1 October 2015

WM Project Number: 14288

**Re: SCEGGS Redlands School (SDD 6454)
Response to Noise Issues raised by NSW Planning and Environment**

Project REDLANDS SENIOR CAMPUS MASTERPLAN Drawing Title PROPOSED MASTERPLAN - BASEMENT AND LEVEL 1 PLANS Drawing No. AR-MP-2001	Revision A

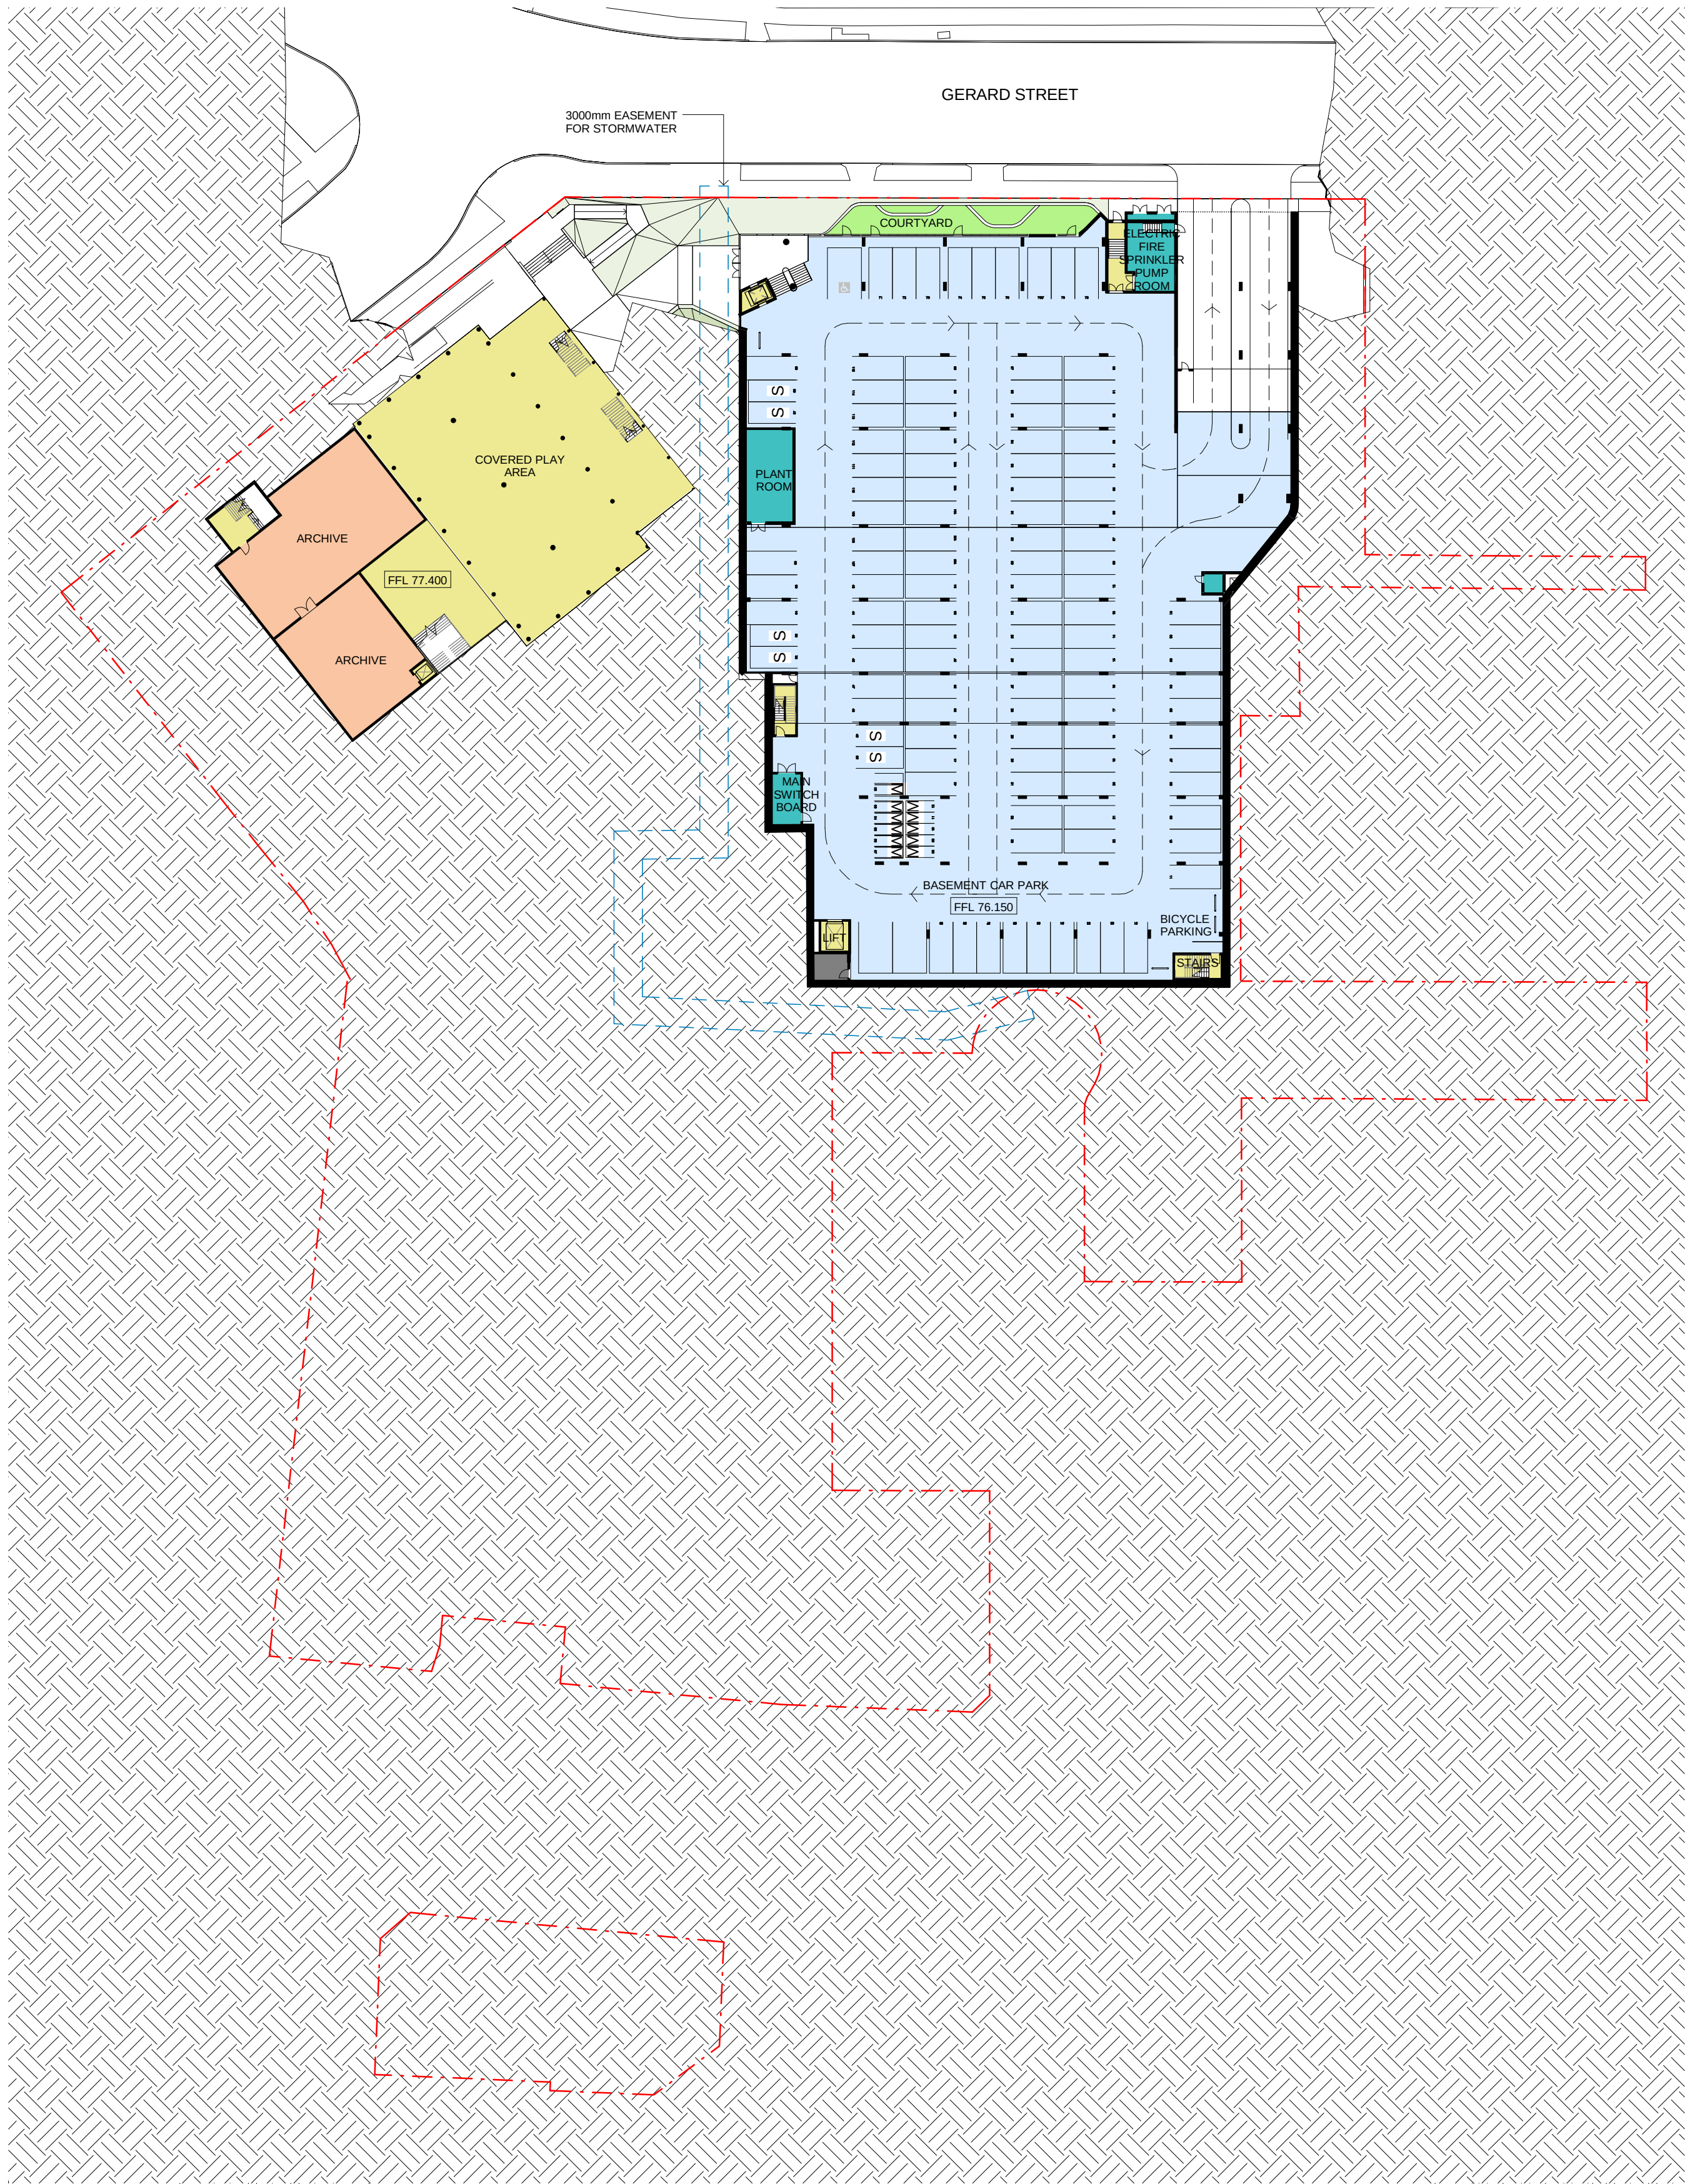
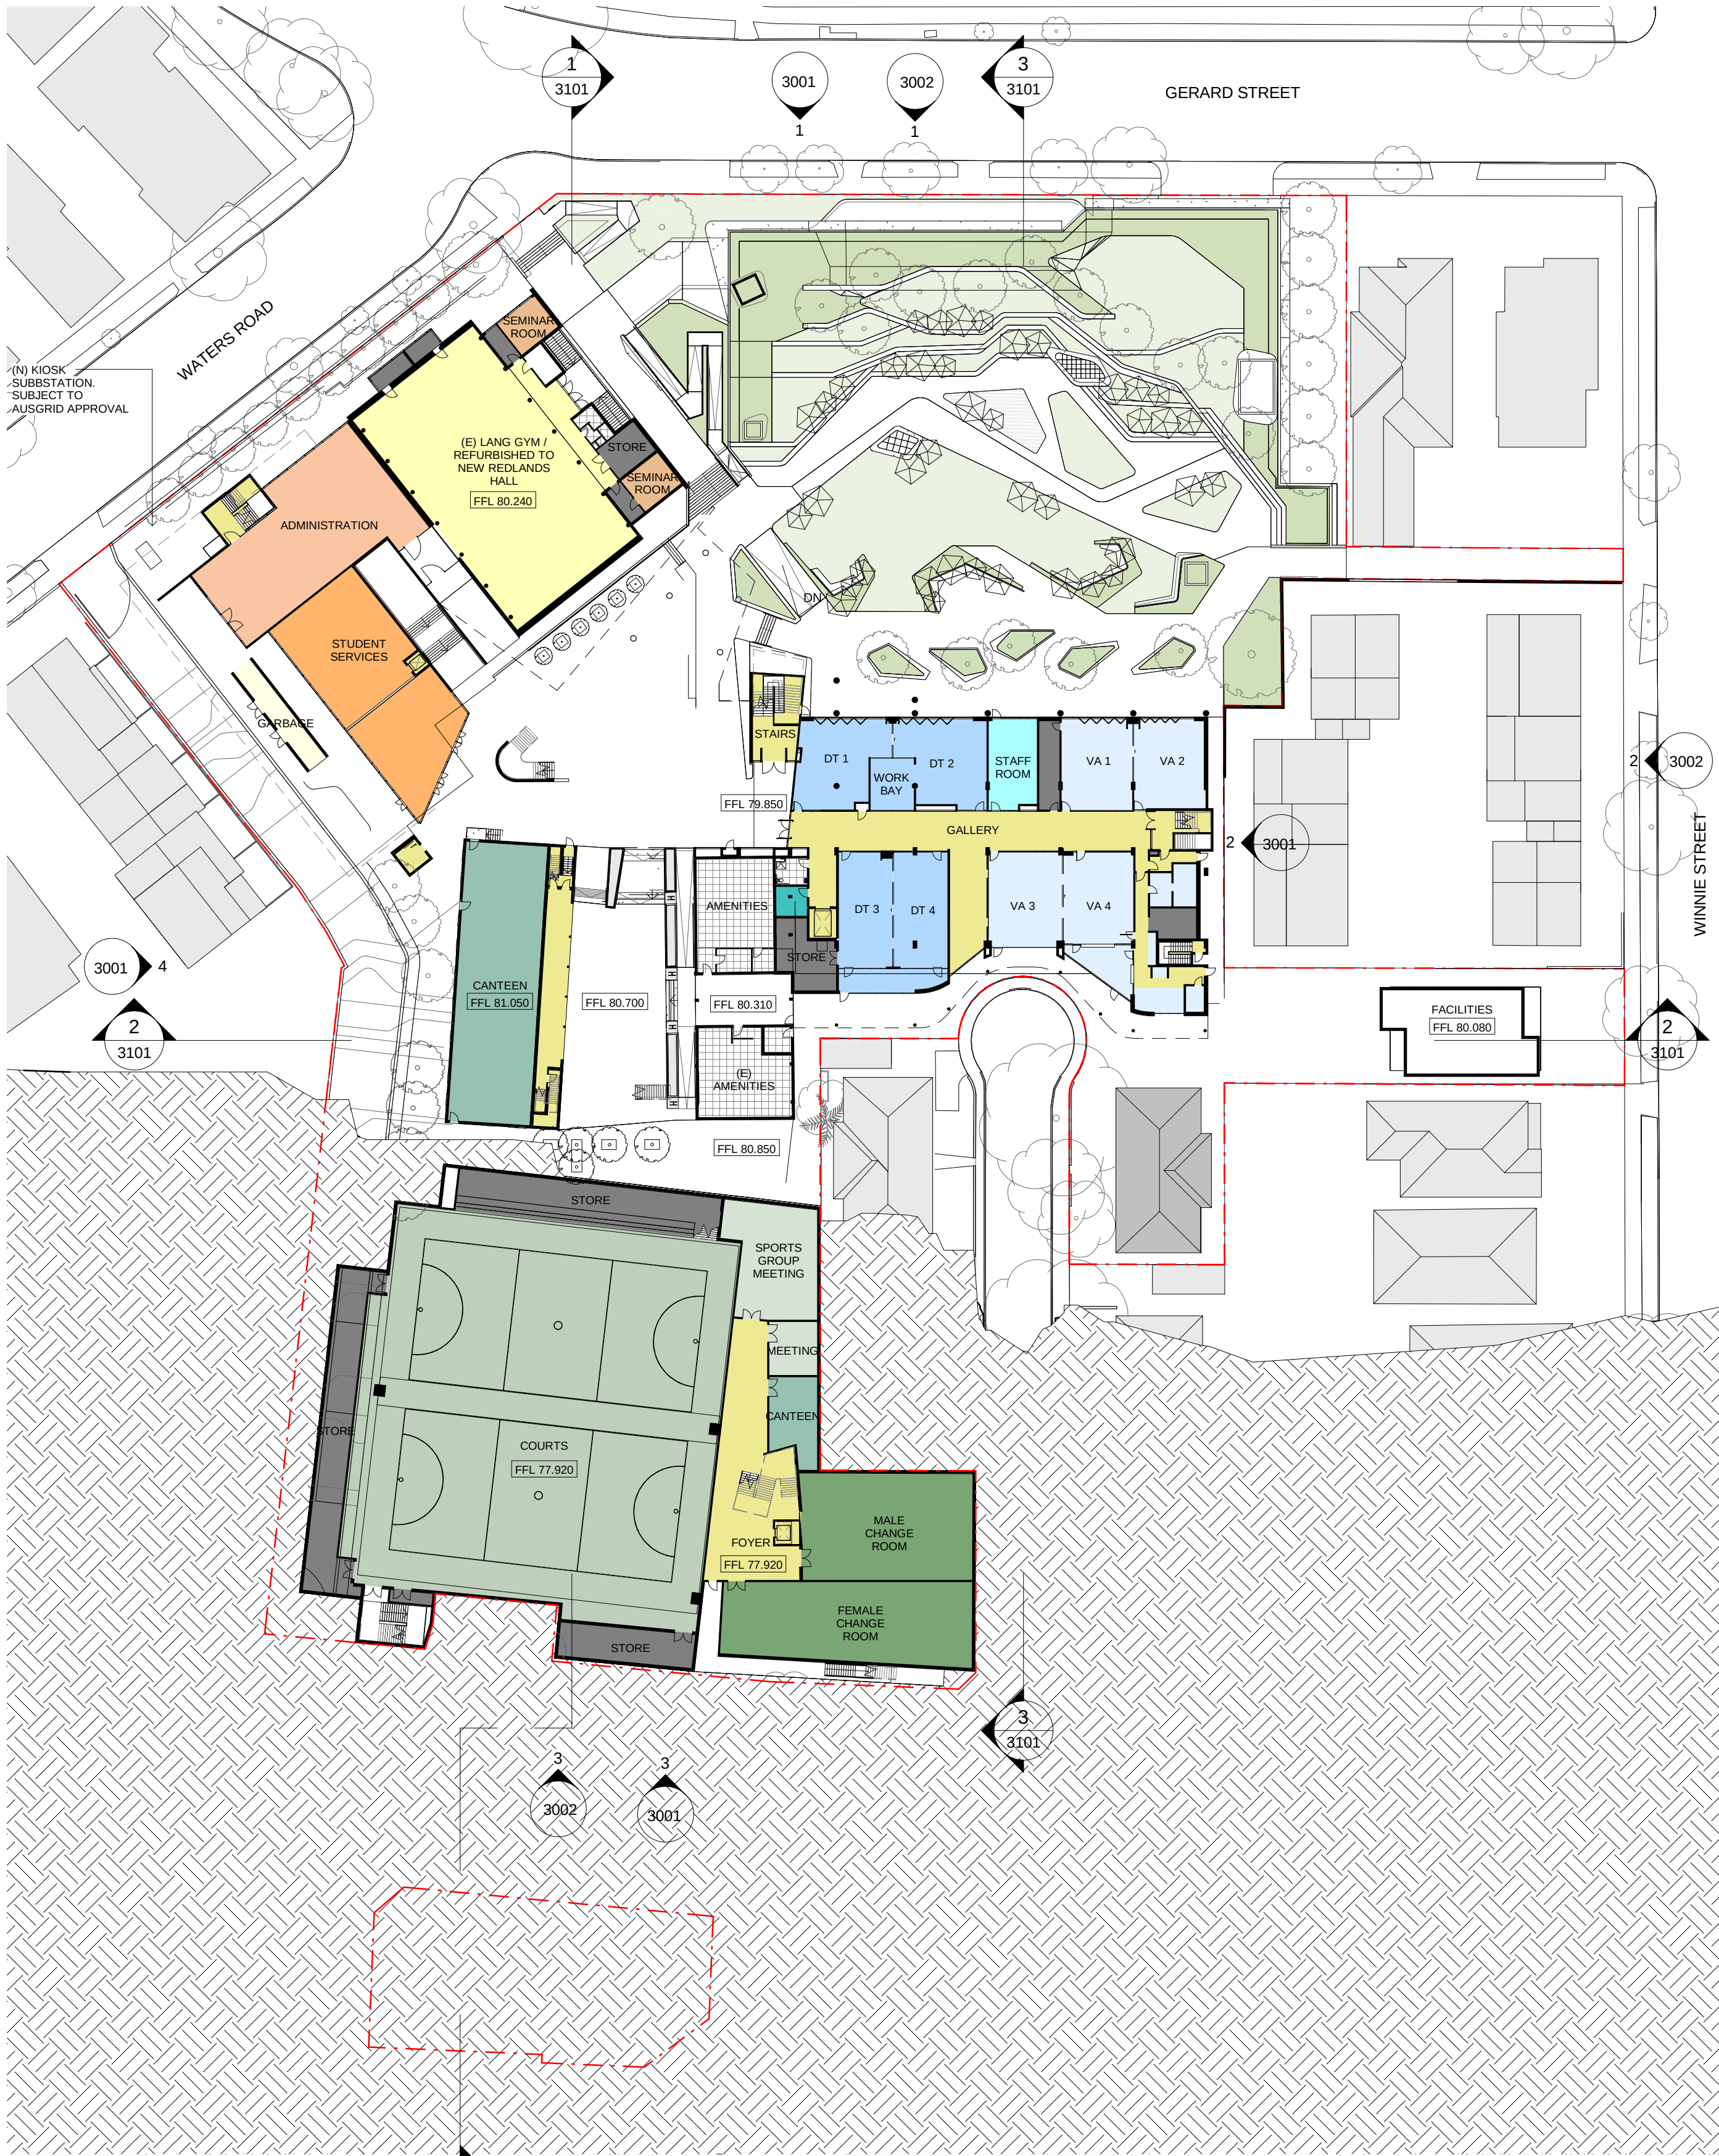
Item 8 The Construction and Operational Noise Report shall be revised to provide consideration and an assessment of amenity impacts on adjoining residential properties from the use of the rooftop swimming pool during the weekday/weekend and use of the proposed new internal link road from Waters Road to Military Road.

It is noted that the proposed swimming pool location has been revised from an outdoor roof level pool proposed in Stage 4 to an enclosed basement level location. The following figure shows this change.

As a result of the relocation of the proposed pool to the basement level any noise generated in this area will be contained within the buildings envelope. Any mechanical plant associated with the pool will be designed to meet the project specific noise criteria that has been established for this project.
